Rezoning Transportation Analysis

Petition Number: 2022-130

Revision Log:

Date	Description
12-28-22	First Review (IW)
02-22-23	Second Review (IW)

Drawing file: revised-site-plans / 2022_130_revsiteplan_2023_02_13.pdf

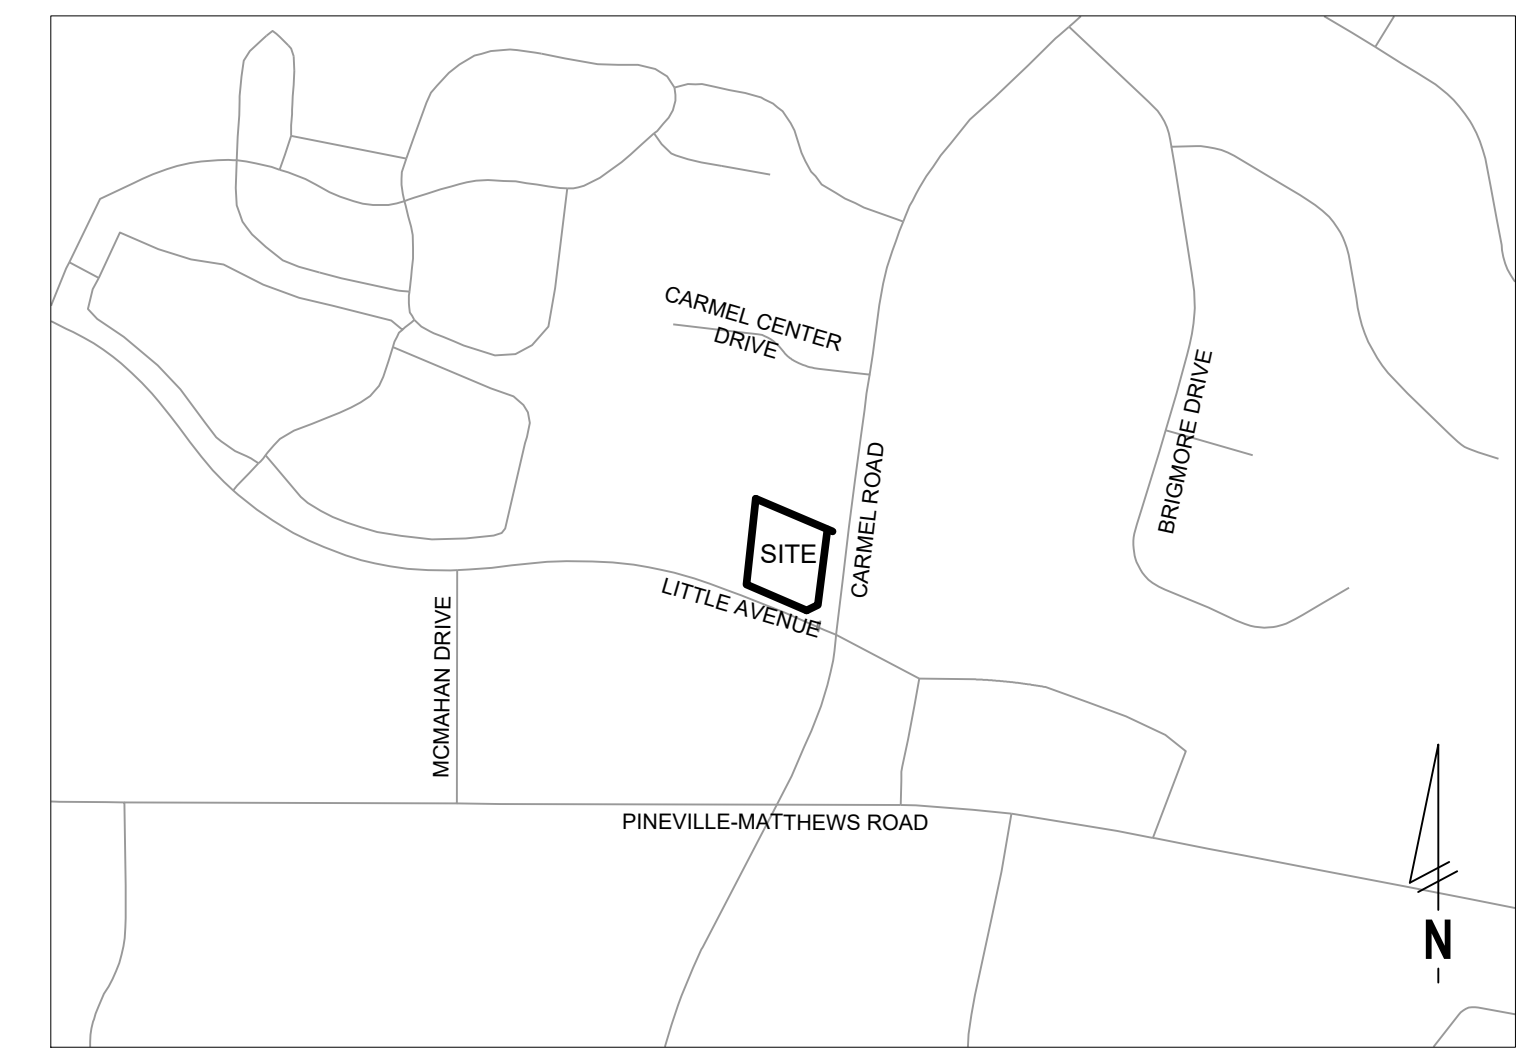
1. Outstanding Comment from 12-28-22 Curblines:

- a. **Carmel Road:** Location of back of curb and gutter to be moved to 33 feet from roadway centerline to accommodate the Charlotte Streets Map with a roadway typical section of CLDSM 11.09 Major Thoroughfare.

Clarifying Note 2-22-23: Site plan is currently showing 32' from centerline, this should be updated to show the future curb line being 33' from centerline.

Label and dimension the curb and gutter from the centerline for each road on the site plan.
